Los Diamantes Subdivision Drainage Management Plan

**RE: Los Diamantes Subdivision
Drainage Report, and Grading and Drainage Plan
Engineer's Stamp Date 3-24-2015 (File: N09D013)**

Re: Los Diamantes Subdivision
Revised Engineers stamp date 6-5-15 (N09 / D013)

Drawing file: june 5 2015 submittal / 14031 Grading Plan Revised 2015-06-05.pdf

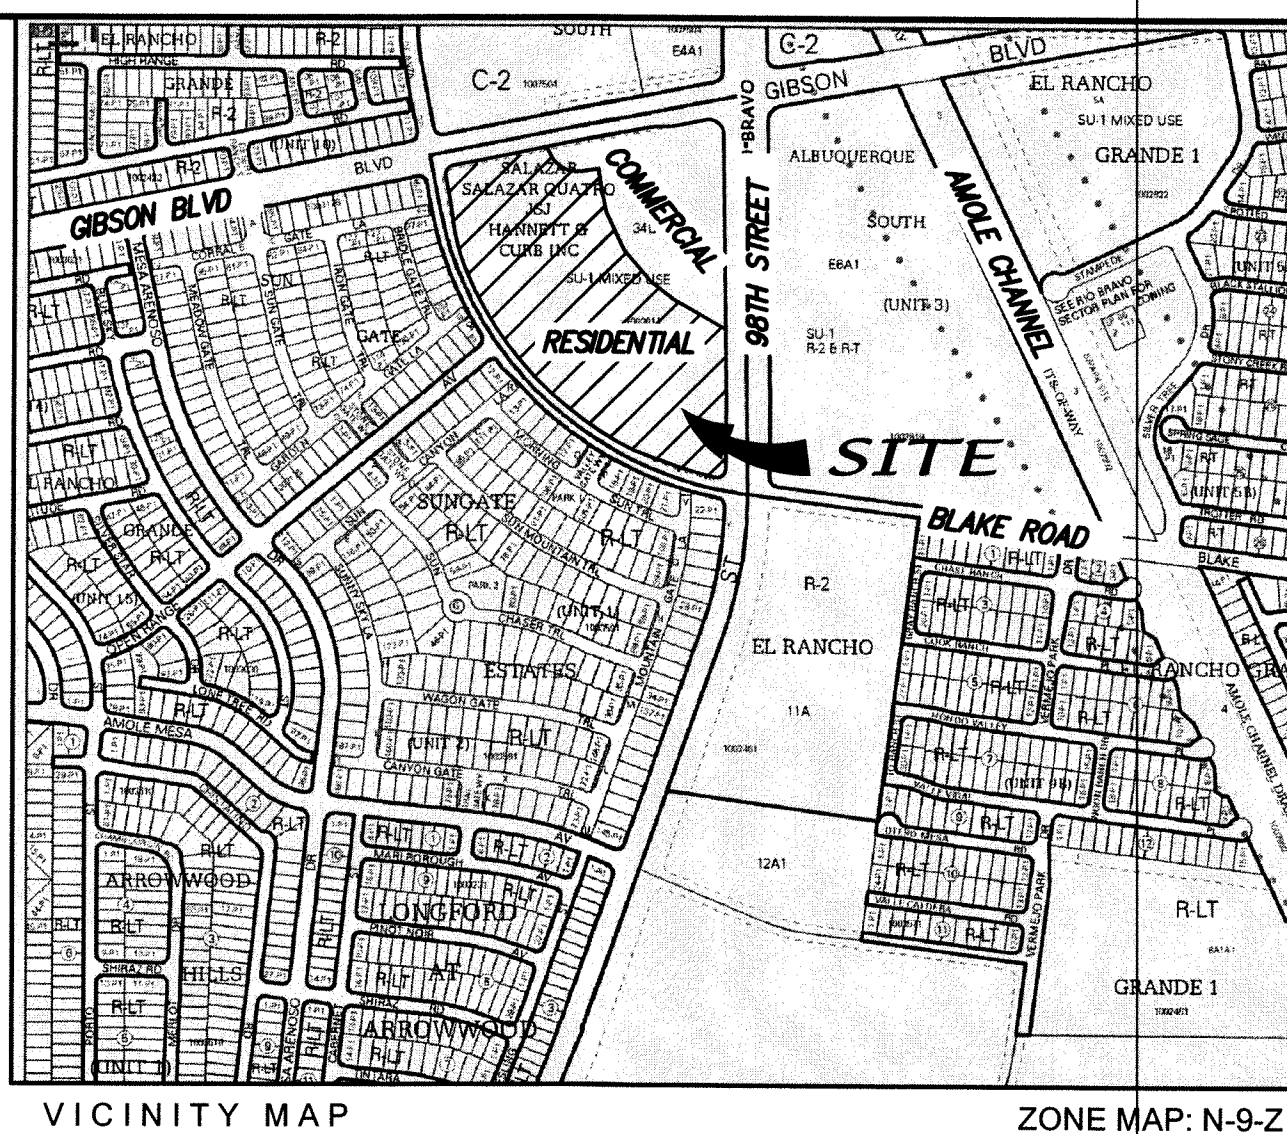
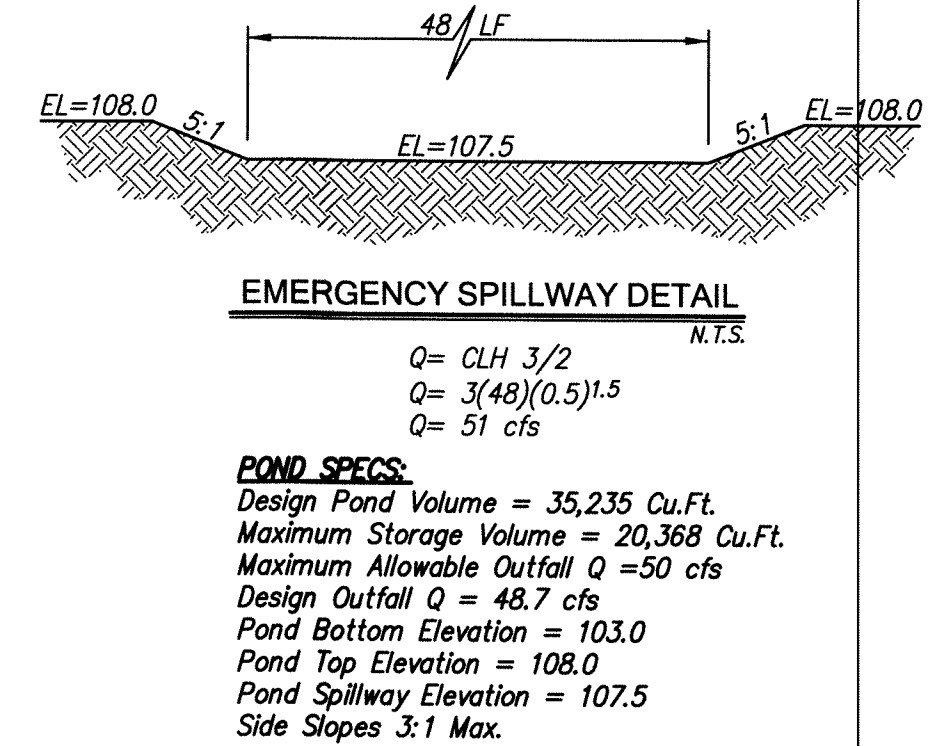
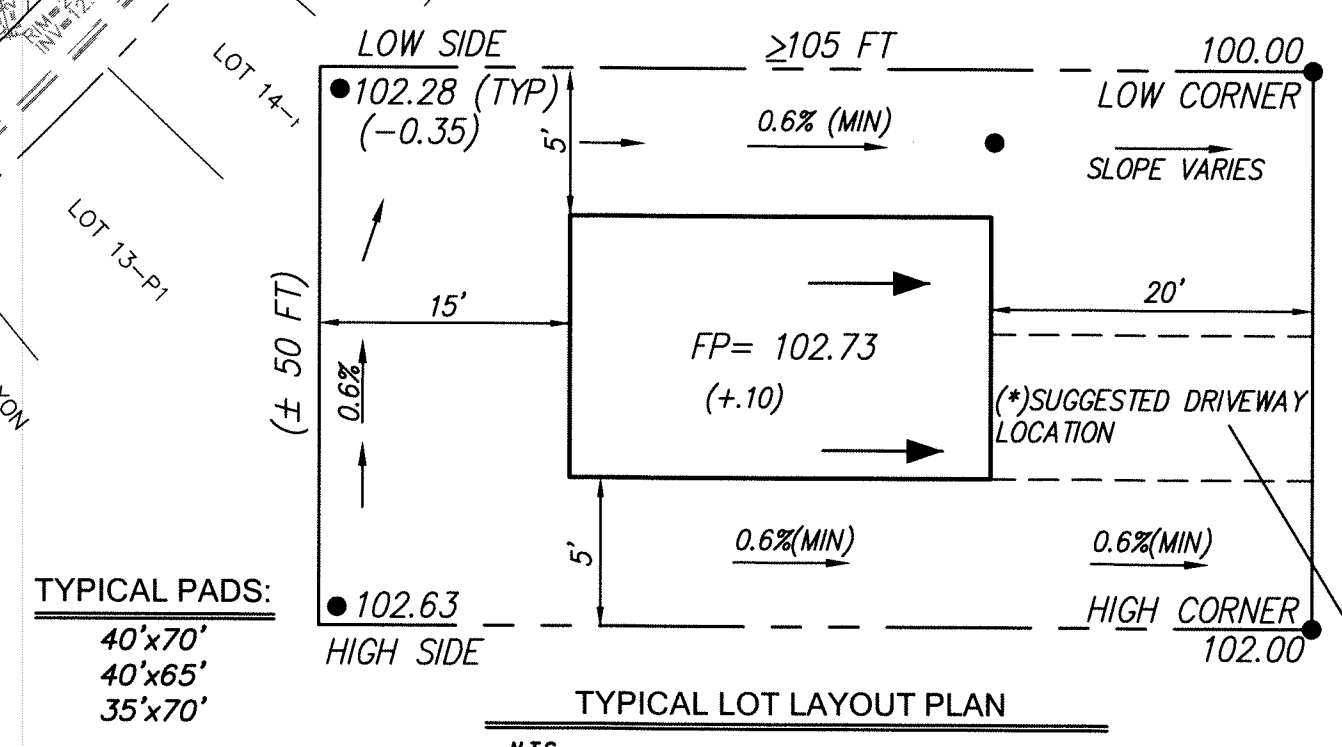
2. It is acceptable to discharge more than the intended 33 cfs into the 30" stub. How is the discharge part of the rating curb calculated in AHYMO? Also show that the 72" SD between MH 16 and 17 has capacity.
3. The grated inlet in Gold dust way Cul-de-sac is not a COA standard. Provide standard inlets.
4. Show Pond Volume on the Plan.
5. If Tract A is intended to discharge into 98th St. in the undeveloped condition, a desilting pond should be shown on the grading plan. Contours show that the SE corner of Tract A is at same elevation as T.O. Curb but view from google earth shows it to be lower than T.O. Curb in that area. Please confirm survey is accurate.

10. The grate shown in Gold Dust Way culdesac is also taken from COA Std dwg 2271 and 2272. It is commonly known as a "cattle guard inlet". I have used these numerous times in other developments. The COA standard details will be modified accordingly to the specific requirements of this project; such as the invert of the channel will be called out as well as the grate elevation and the actual length of the channel.
